HINCKLEY NATIONAL RAIL FREIGHT INTERCHANGE

Project reference TR050007

Applicant's Response to Deadline 4 Submissions [part 2 - HBBC]

Applicant's Response to HBBC Deadline 4 Submission - Response to Additional Deadline 3 Submissions

Written Statement of Oral Case ISH6 [Appendix C – Plan for A47 link road footway/cycleway design]

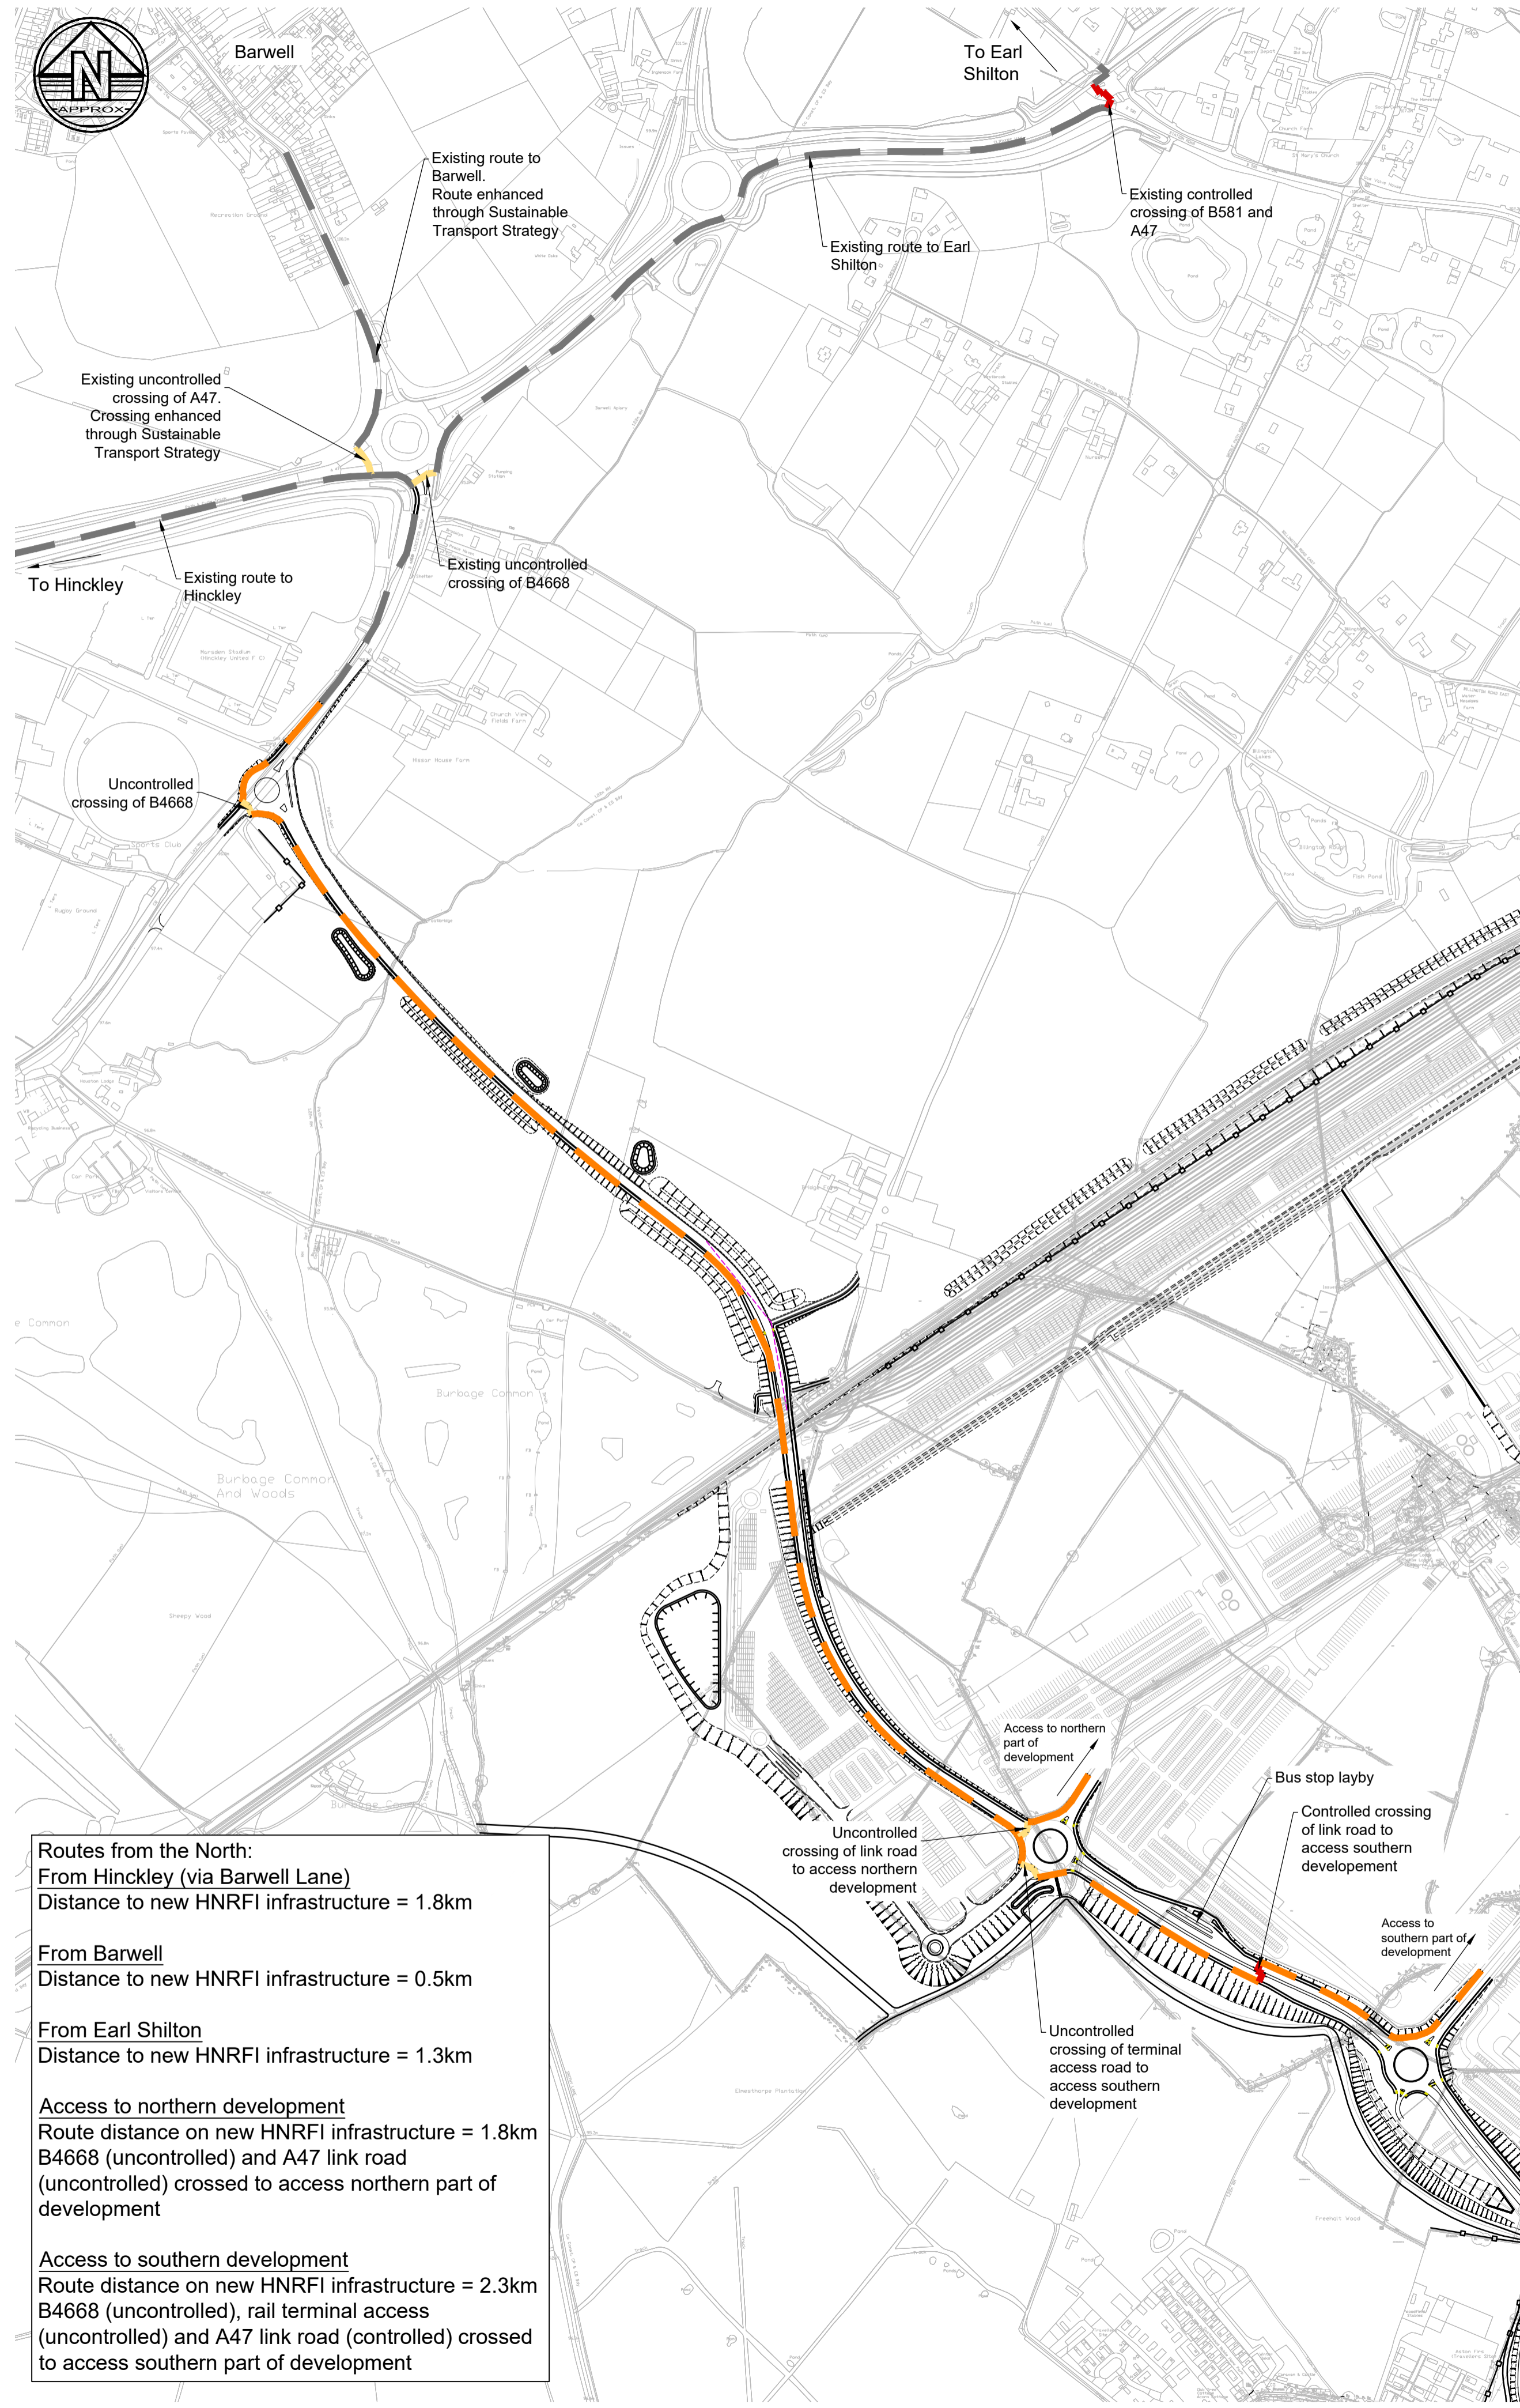
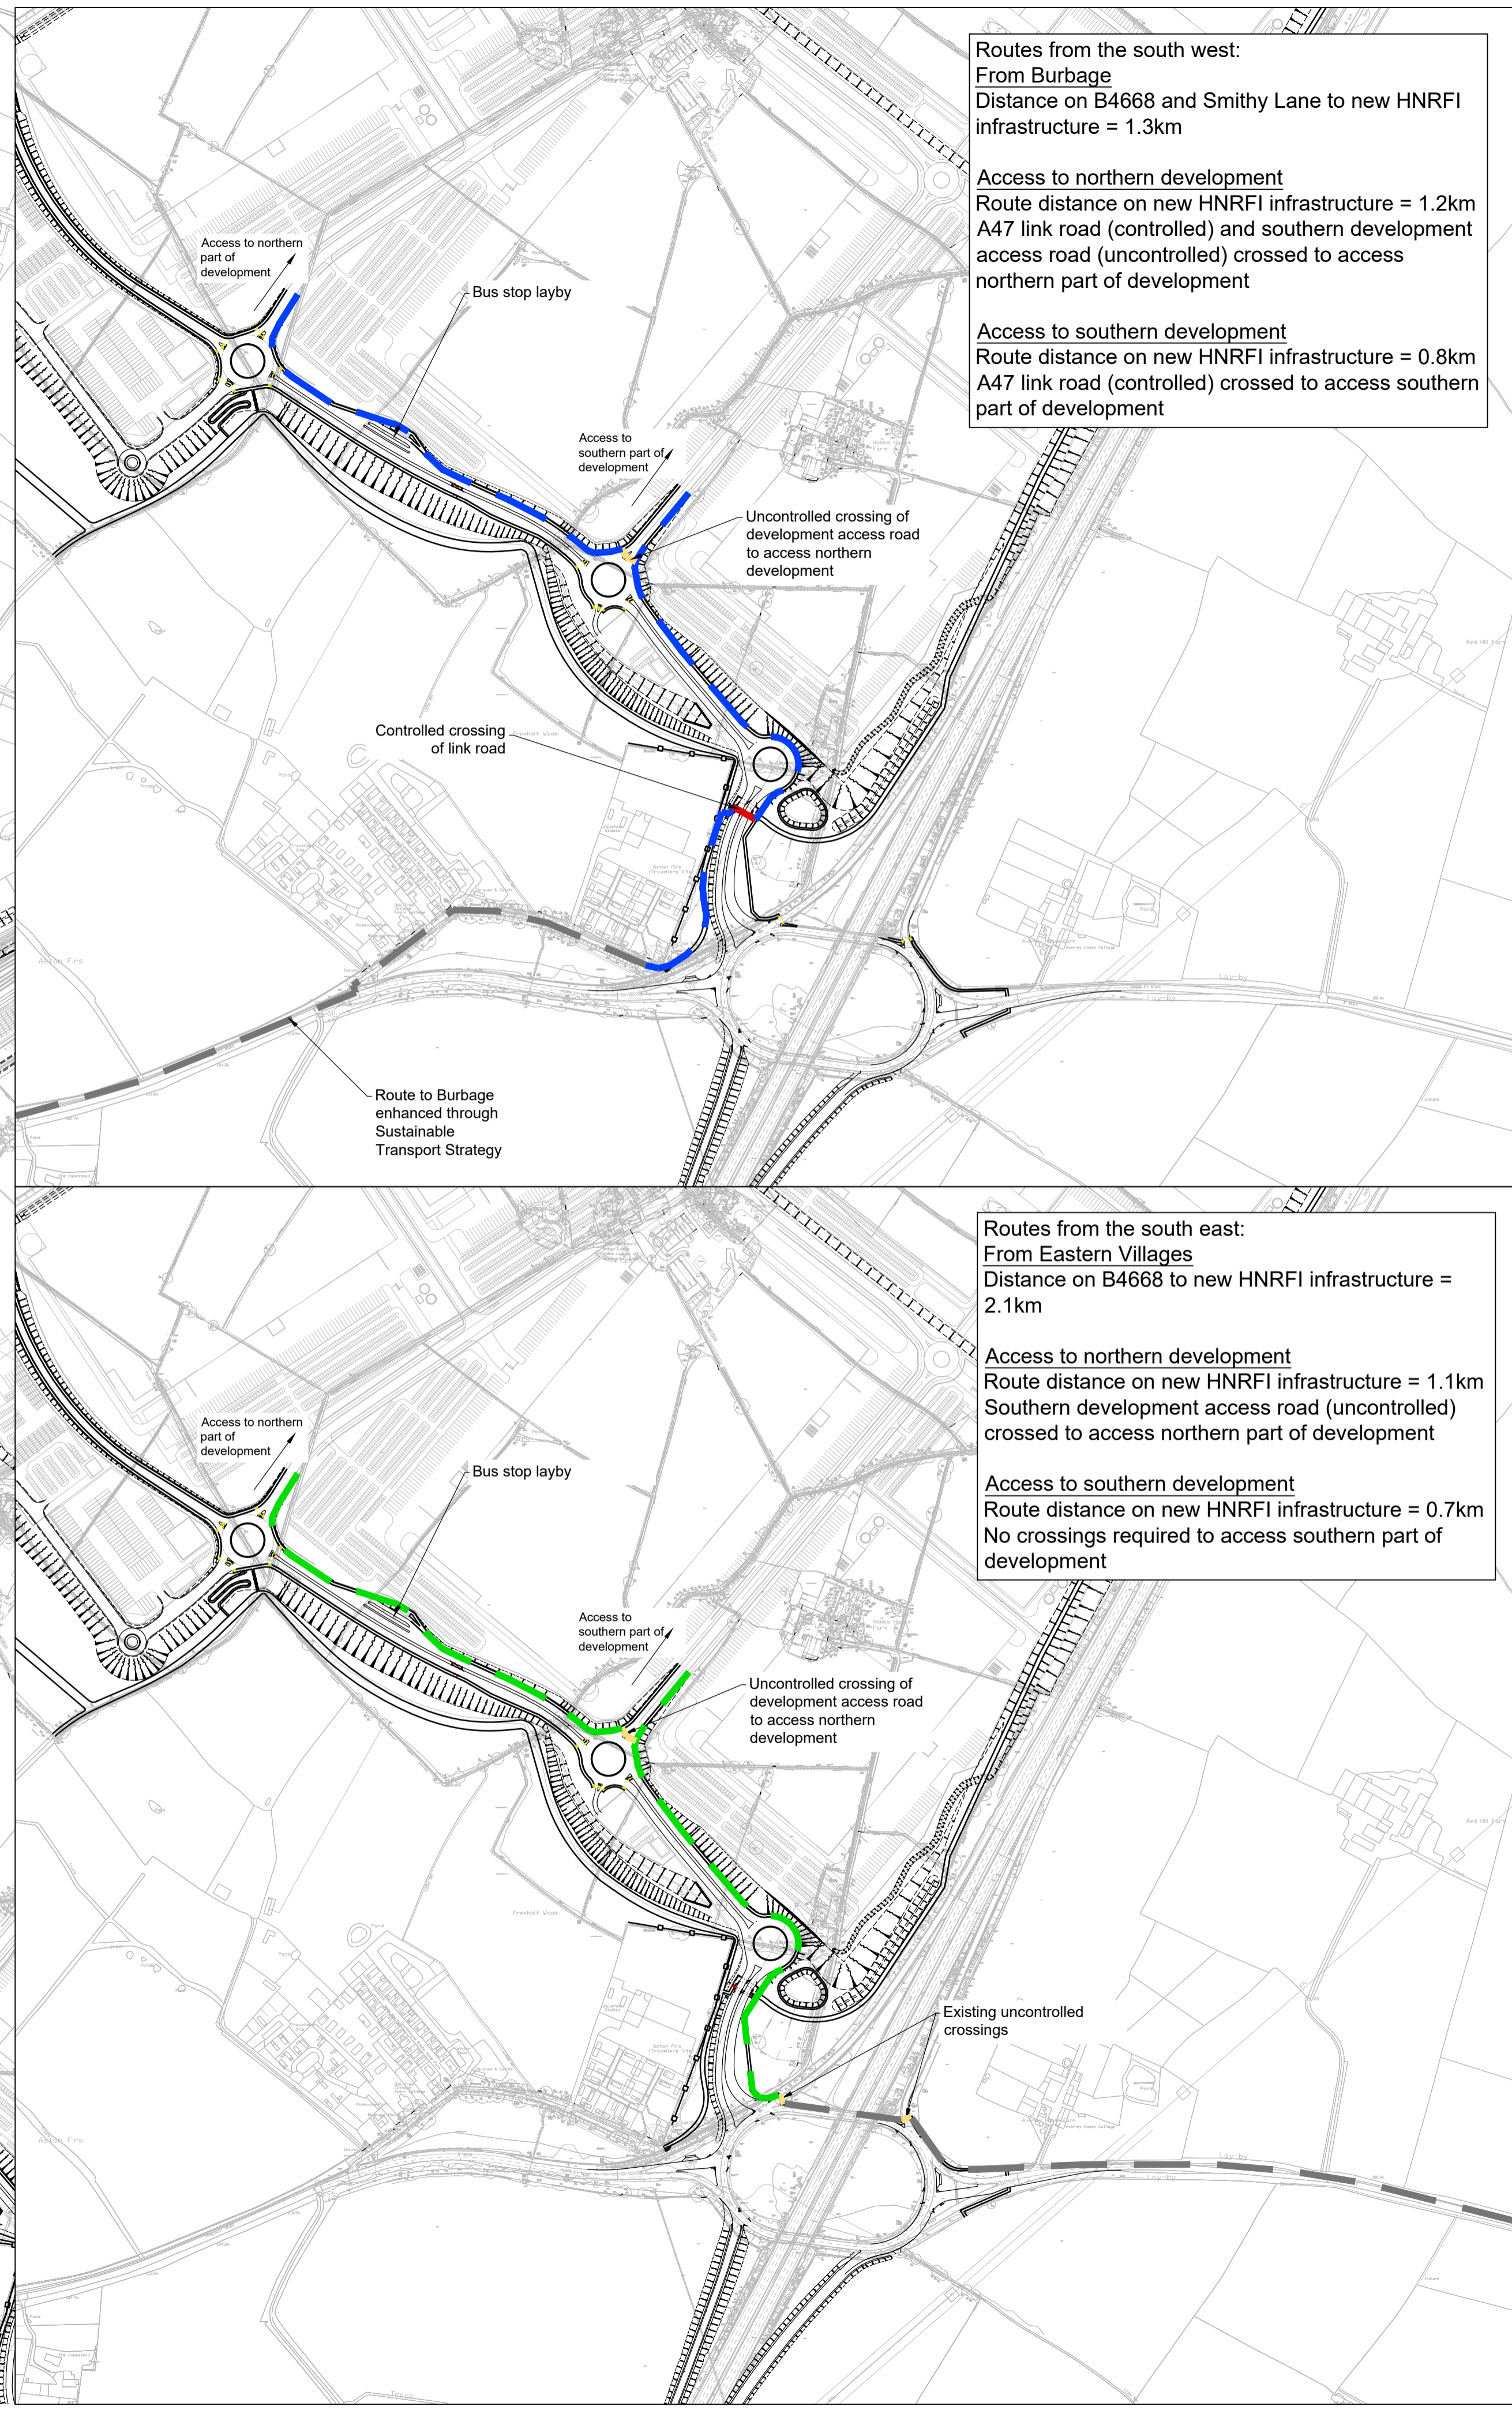
No	ExQ Ref	Hinckley & Bosworth Council Response	Applicant's Response
	Plans for Burbage Common Road	they show a 'proposed permissive path' for walkers and cyclists along the A47 – but the Council would expect these to be part of the publicly adopted highway and thus, not permissive paths. The council has expressed concern at details of these routes including the need to cross the link road in path continuity and how safe and what quality the permissive paths will be across the site as well as crossing facilities - these concerns remain.	adopted paths. A plan showing the footpath / cycleway A47 link road design including crossing points is submitted as Written Statement of Oral Case ISH6 (Appendix C – Plan for A47 link road footway / cycleway design (document reference 18.15.3).
	REP3 – 018 – Framework Travel Plan		Written Statement of Oral Case ISH6 [Appendix C - Plan for A47 link road footway/cycleway design]
